**Subject:** RE: AB/54/22/DOC

However, it is clear from the response provided by the applicant that two of the consultation comments (1 and 4) have not been satisfactorily addressed. **On this basis I recommend that the application is refused.** It is suggested

Catchpit Type N
Scale 1:10

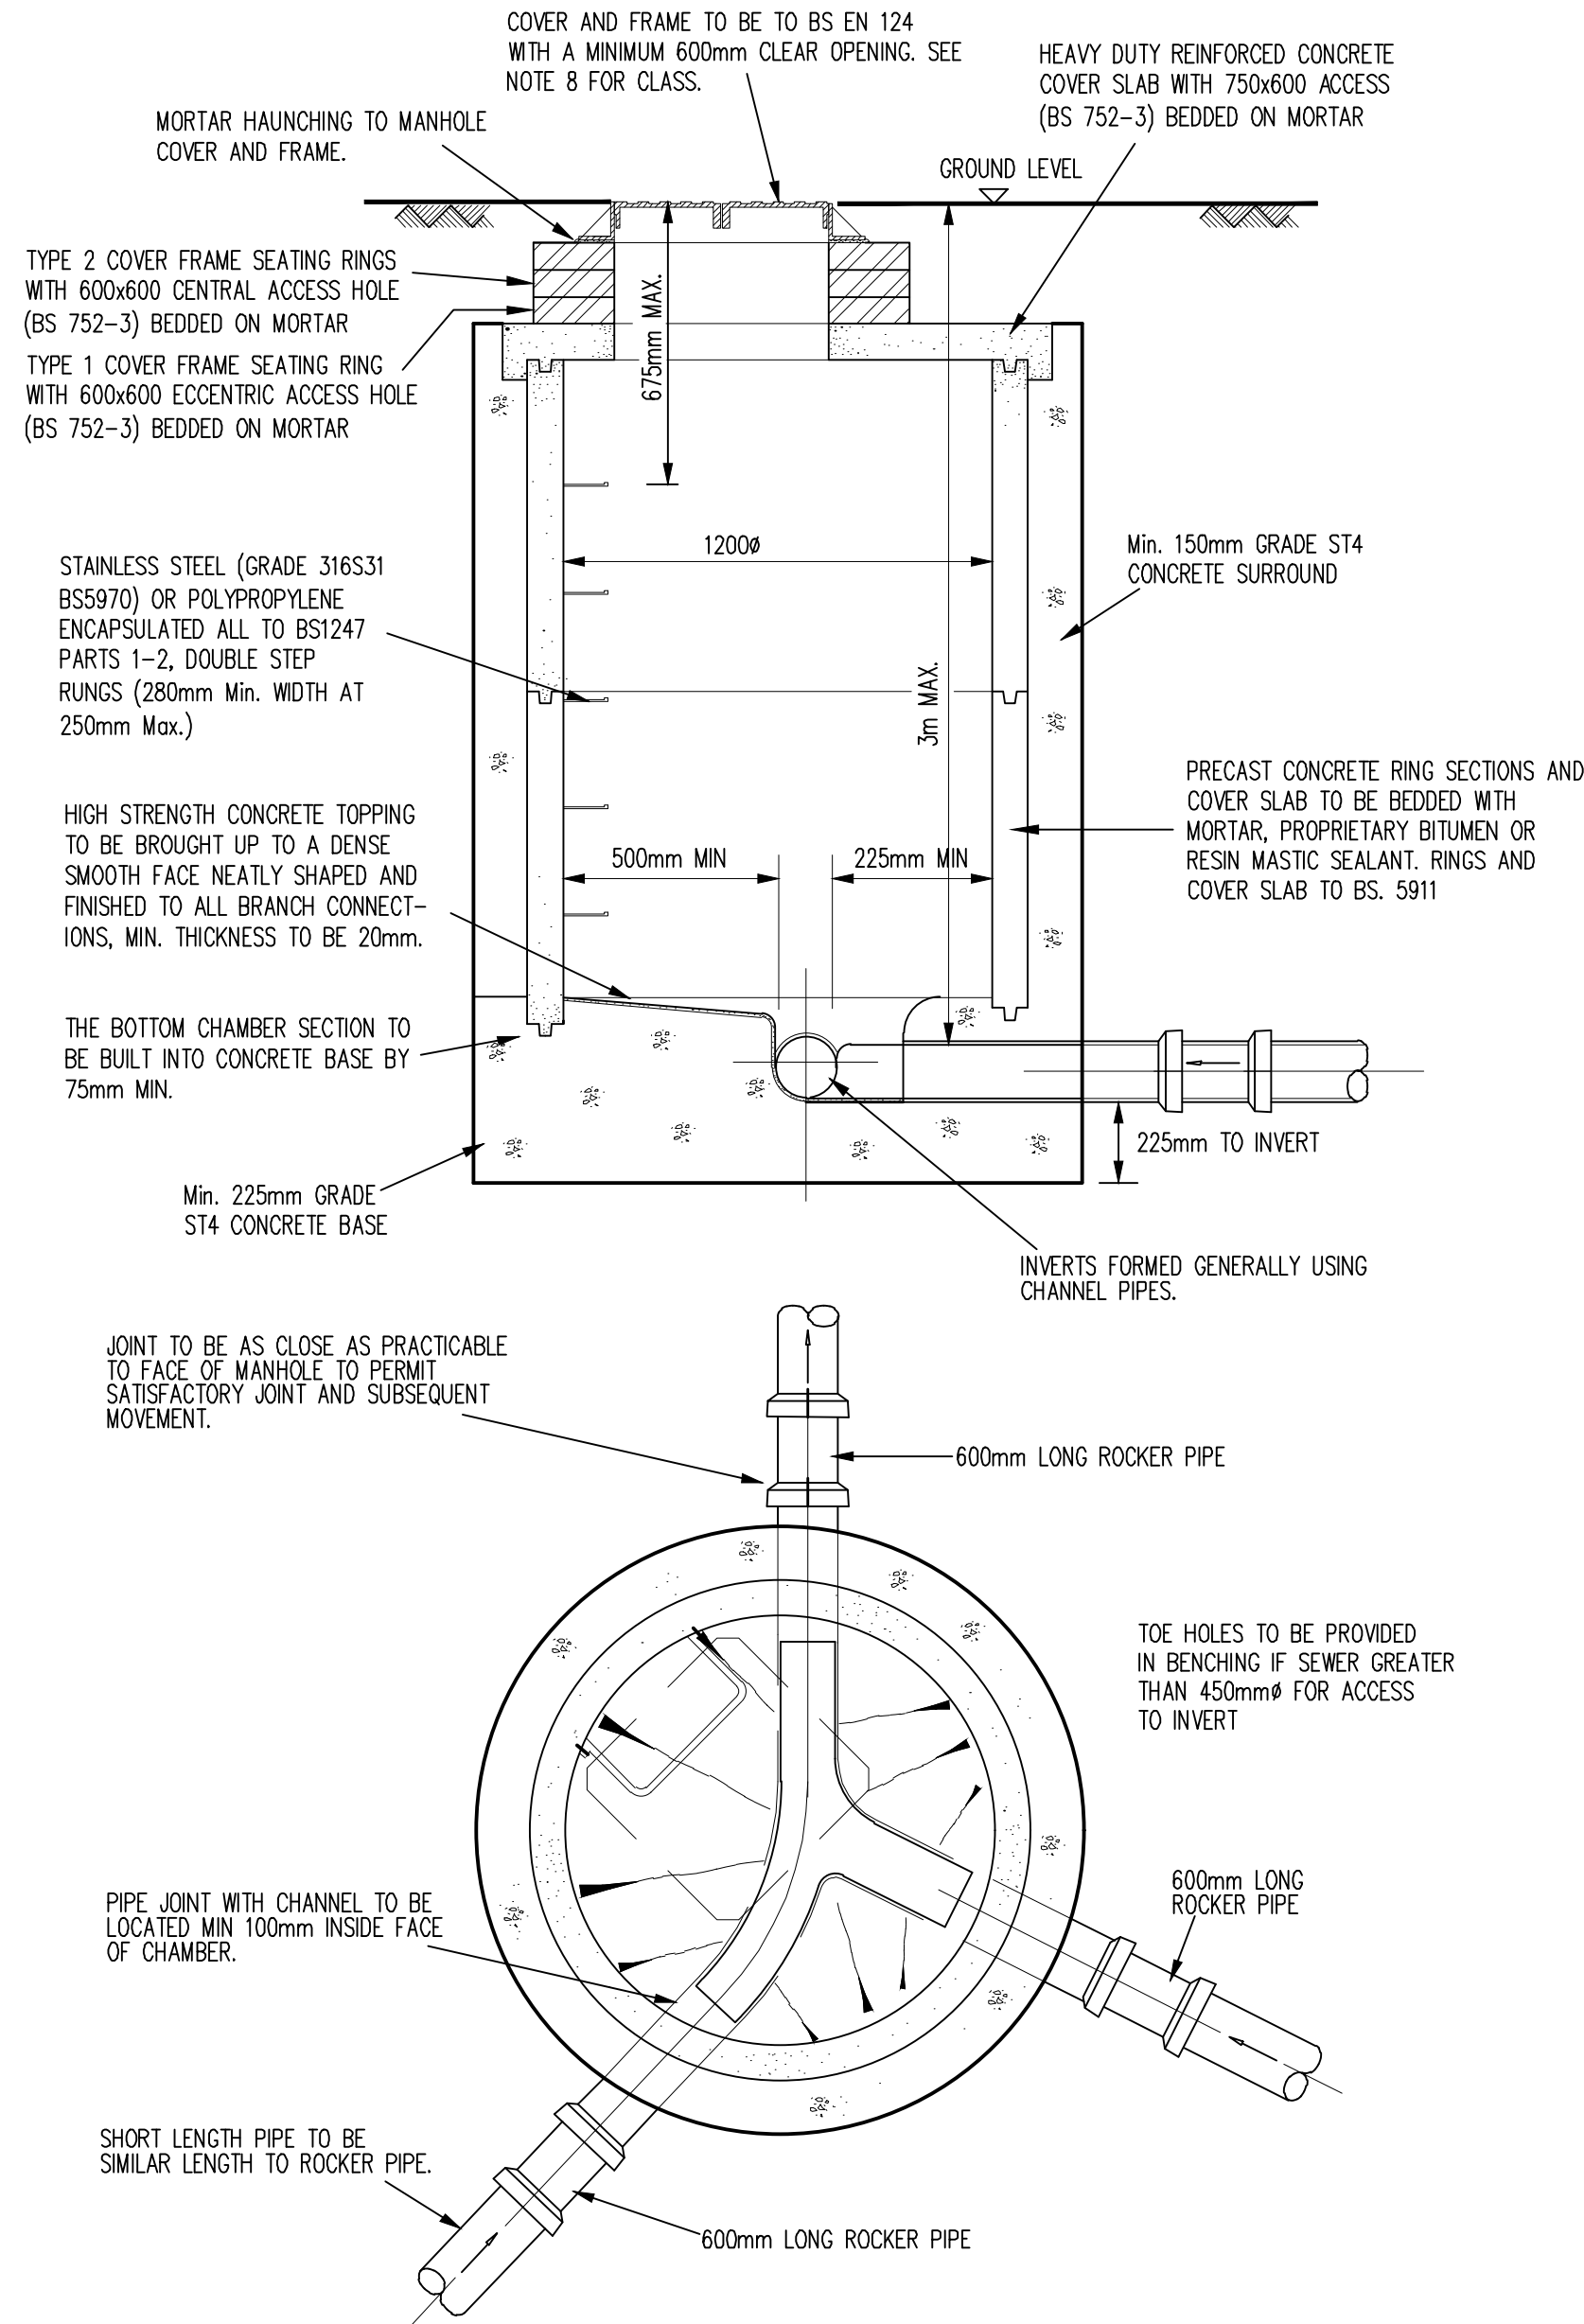
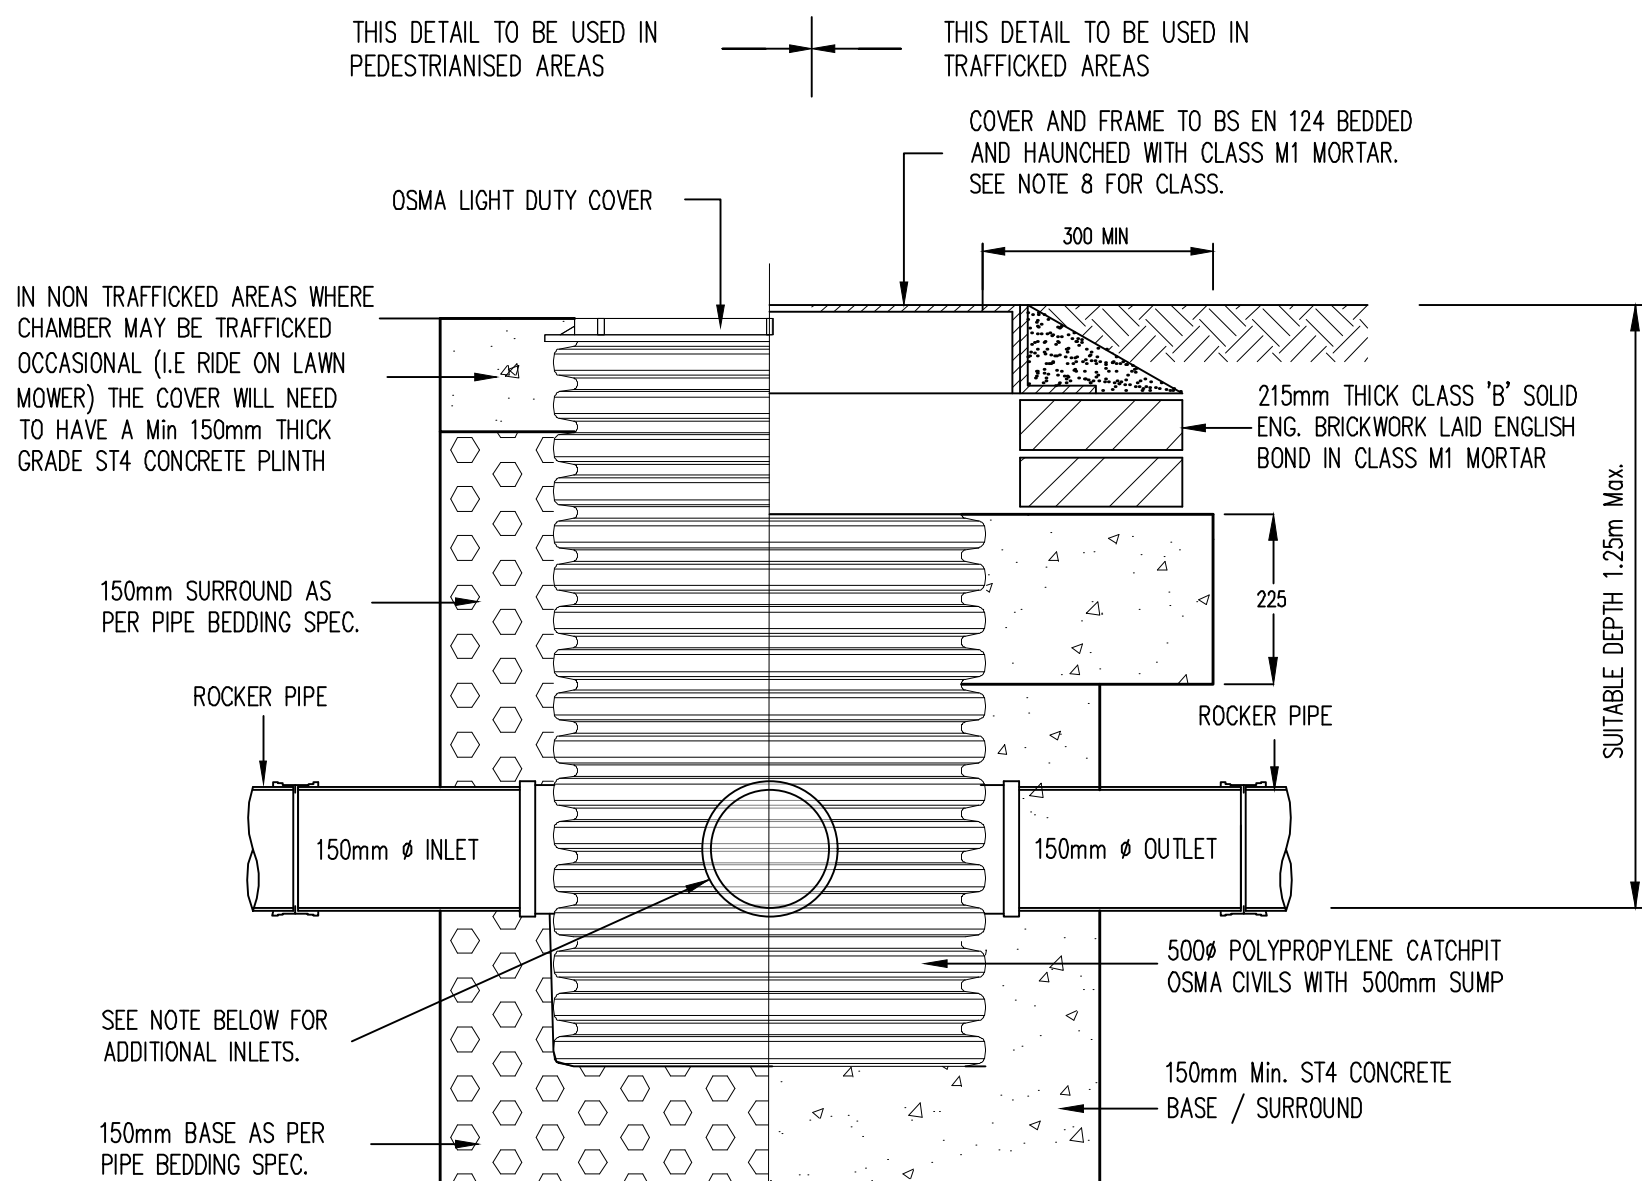
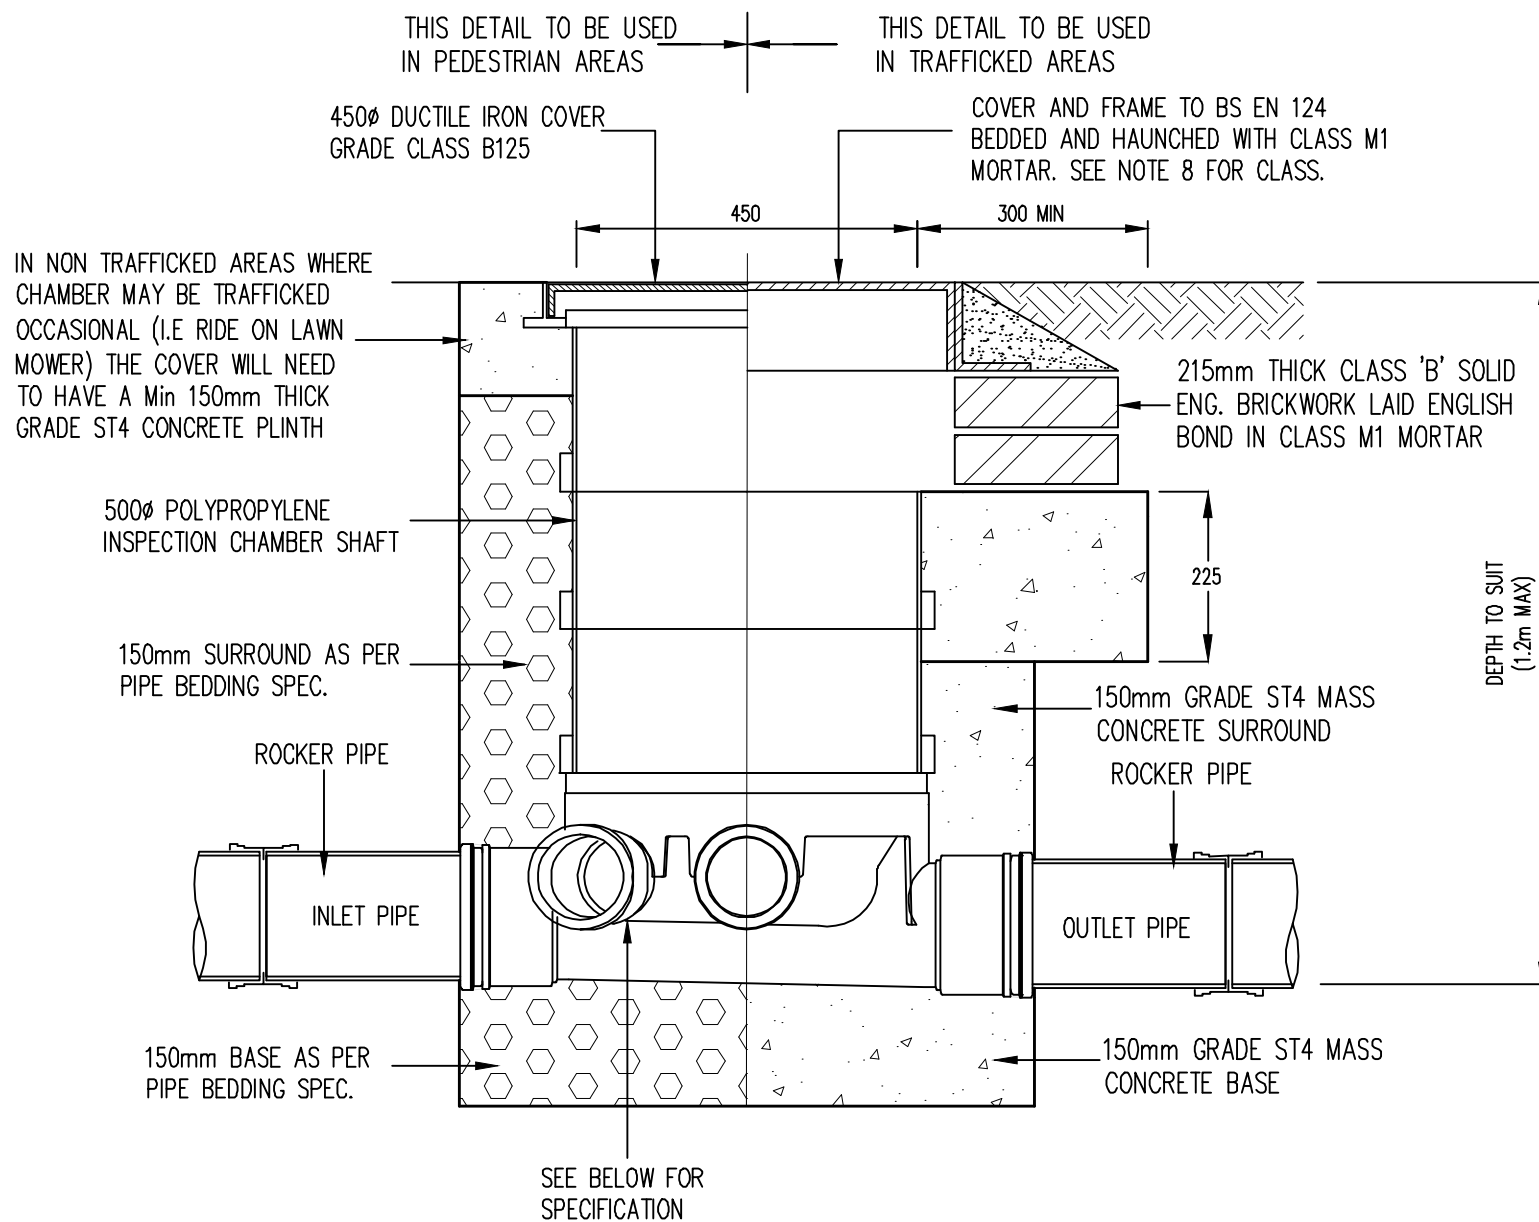
17. The catchpit drawings should include a dimension to confirm the minimum depth of the catchpit below the inlet and outlet invert levels. This depth should be a minimum of 300mm in line with our policy requirements.

All the proposed catchpits have a minimum sump depth of 300mm as per the attached detail drawings.
